Final Review Comments for 169 Newbury St - Luminato

Re: 169 Newbury St – Luminato Condominiums

The Department of Public Services has the following review comments on the above proposed project.

5 CATCHBASIN #2 SECTION (II-2)
NOT TO SCALE

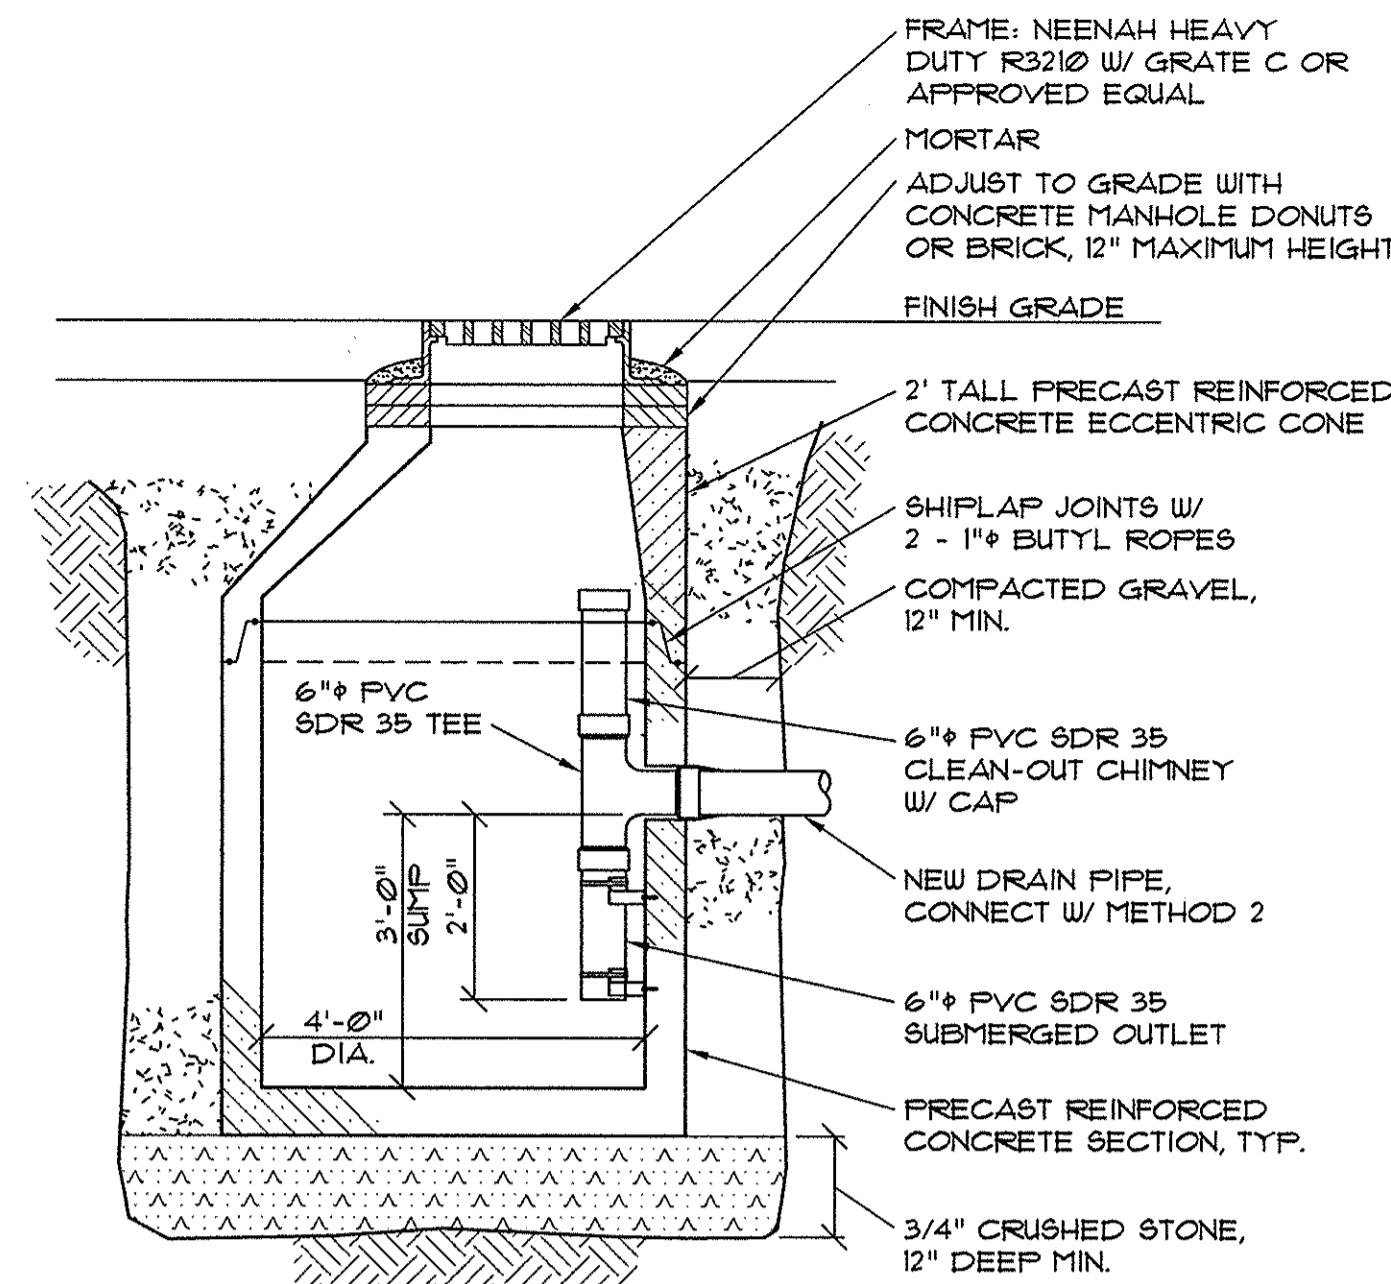
4. It is understood that all roof and site drainage will be directed to proposed catchbasin #2 in Newbury St. or to the ground and not the sanitary sewer system. Please confirm that this is the case. Please note that N-12 is not permitted within the street right of way. Please consult Chapter Two of the City's Technical Manual for acceptable pipe material options.

7. An oil/grit separator will be required within the parking garage on both levels. Modifying the proposed catchbasin to include a three foot sump and down turned 90 degree bend to allow for one foot of oil capture is acceptable. Please show detail and indicate oil/grit locations on plans. Please keep the sanitary lateral connections downstream of the oil/grit separators and change the designation of the line from SD leading to the City's sanitary sewer.

All site drainage will be conveyed to Hampshire St and N-12 will not be used.

This issue has been addressed.

8 TYPICAL BACKFLOW PREVENTOR DETAIL
NOT TO SCALE

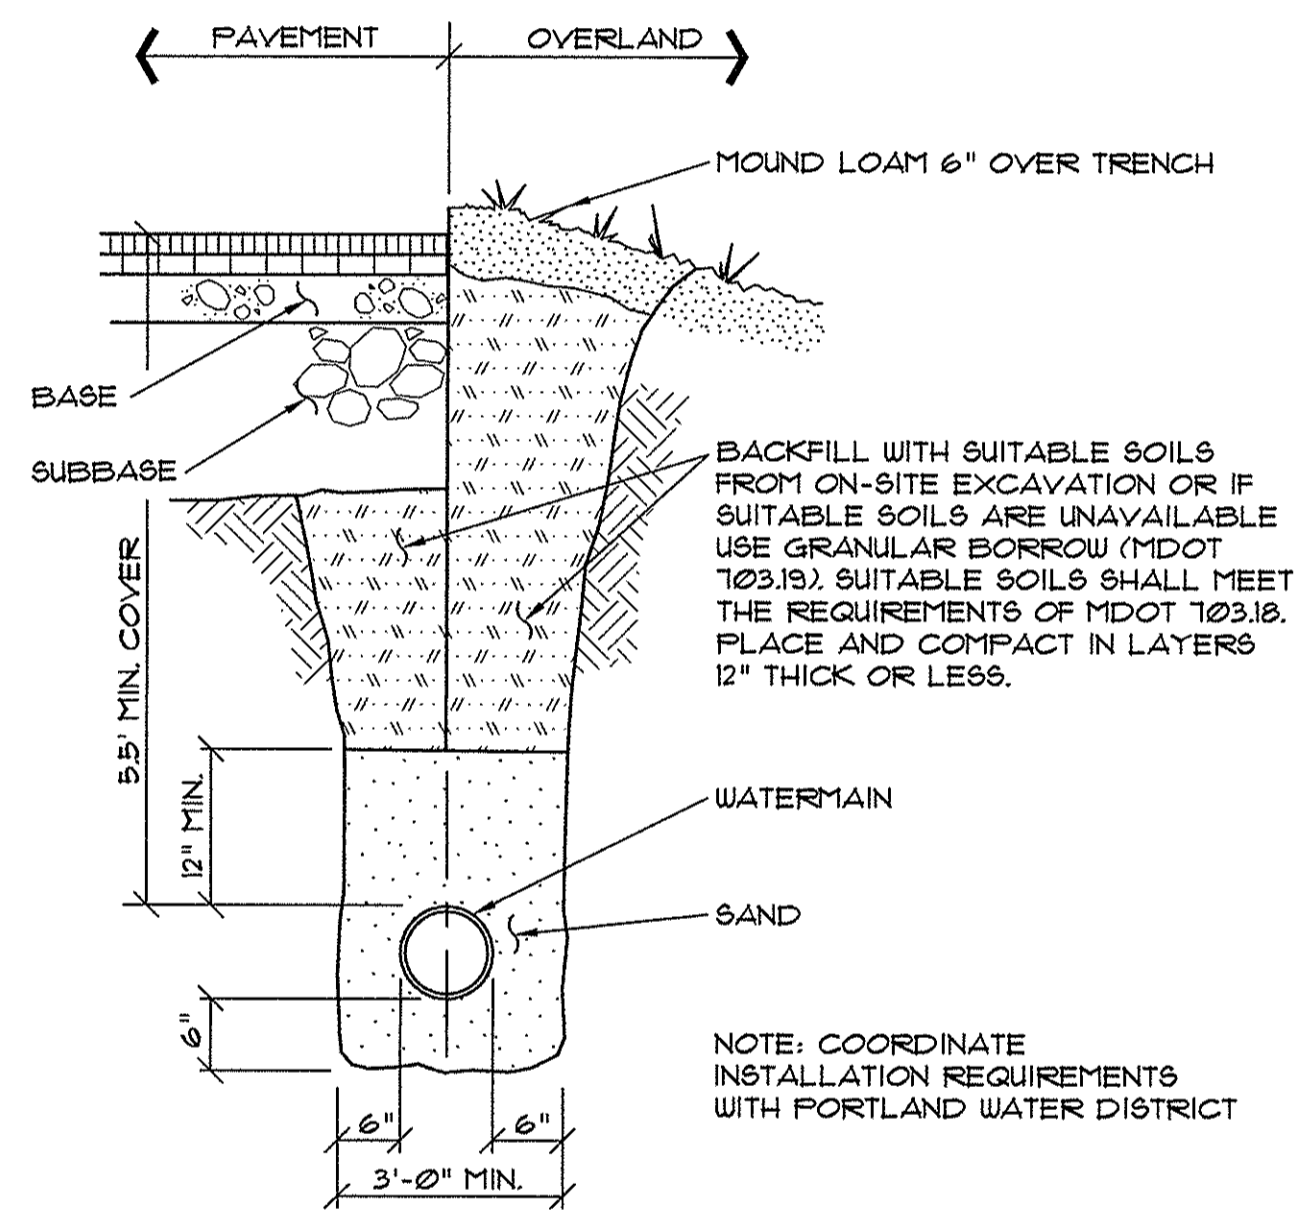
8. Since the sewer systems are separated, a backflow preventer on the sanitary lateral is not required by the city. If the applicant wishes to install one, please place the backflow preventer on the applicant's property.

Issued resolved. The backflow preventer has be eliminated.

**5 BITUMINOUS DRIVEWAY APRON (I-13)**  
NOT TO SCALE

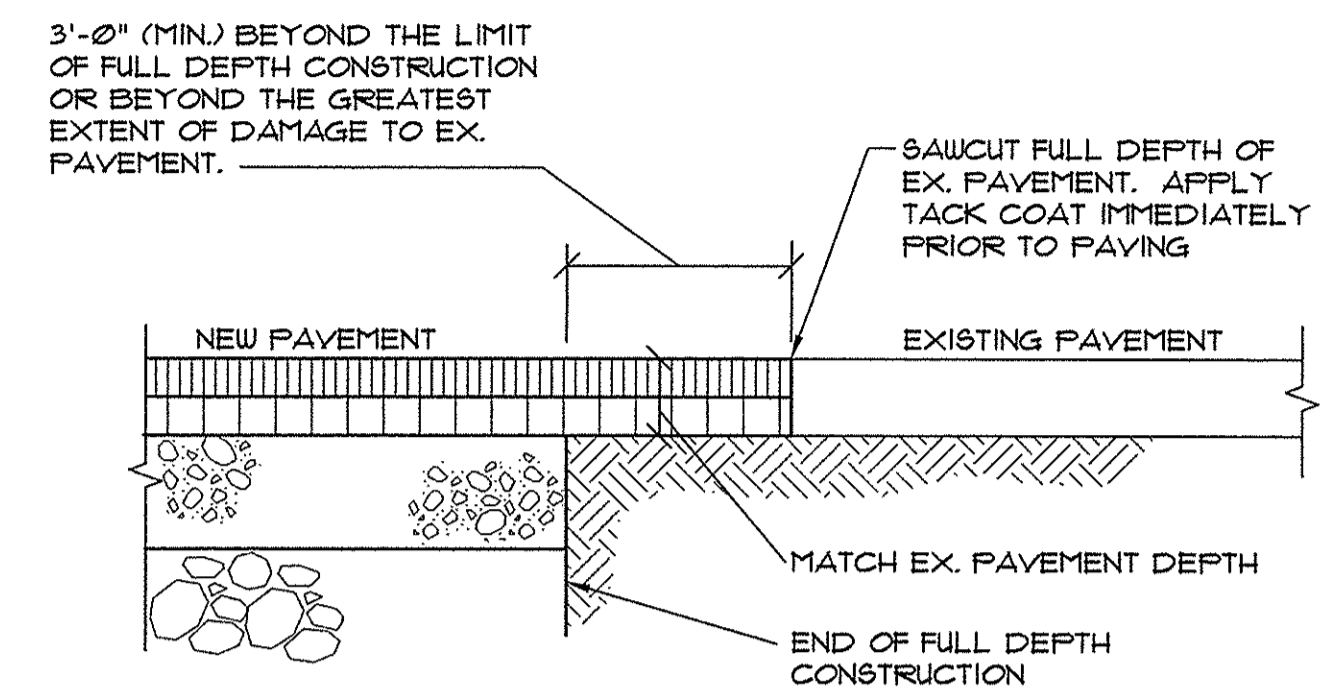
5. The applicant is showing a brick driveway apron within the street right of way on Newbury St.

This is a deviation of the City's material policy which calls for an asphalt apron. This department is supportive of a waiver request however the applicant will need Council approval and signoff on maintenance agreement of the drive apron within the road right of way.

- Based upon my review of site characteristics the proposed project is not expected to cause unreasonable highway or public road congestion or unsafe conditions with respect to impacts to the public street system.
- The driveway apron on Newbury Street shall be designed so that a maximum 2% cross-slope is constructed for pedestrians walking along Newbury Street.

Drive aprons have been changed to asphalt.
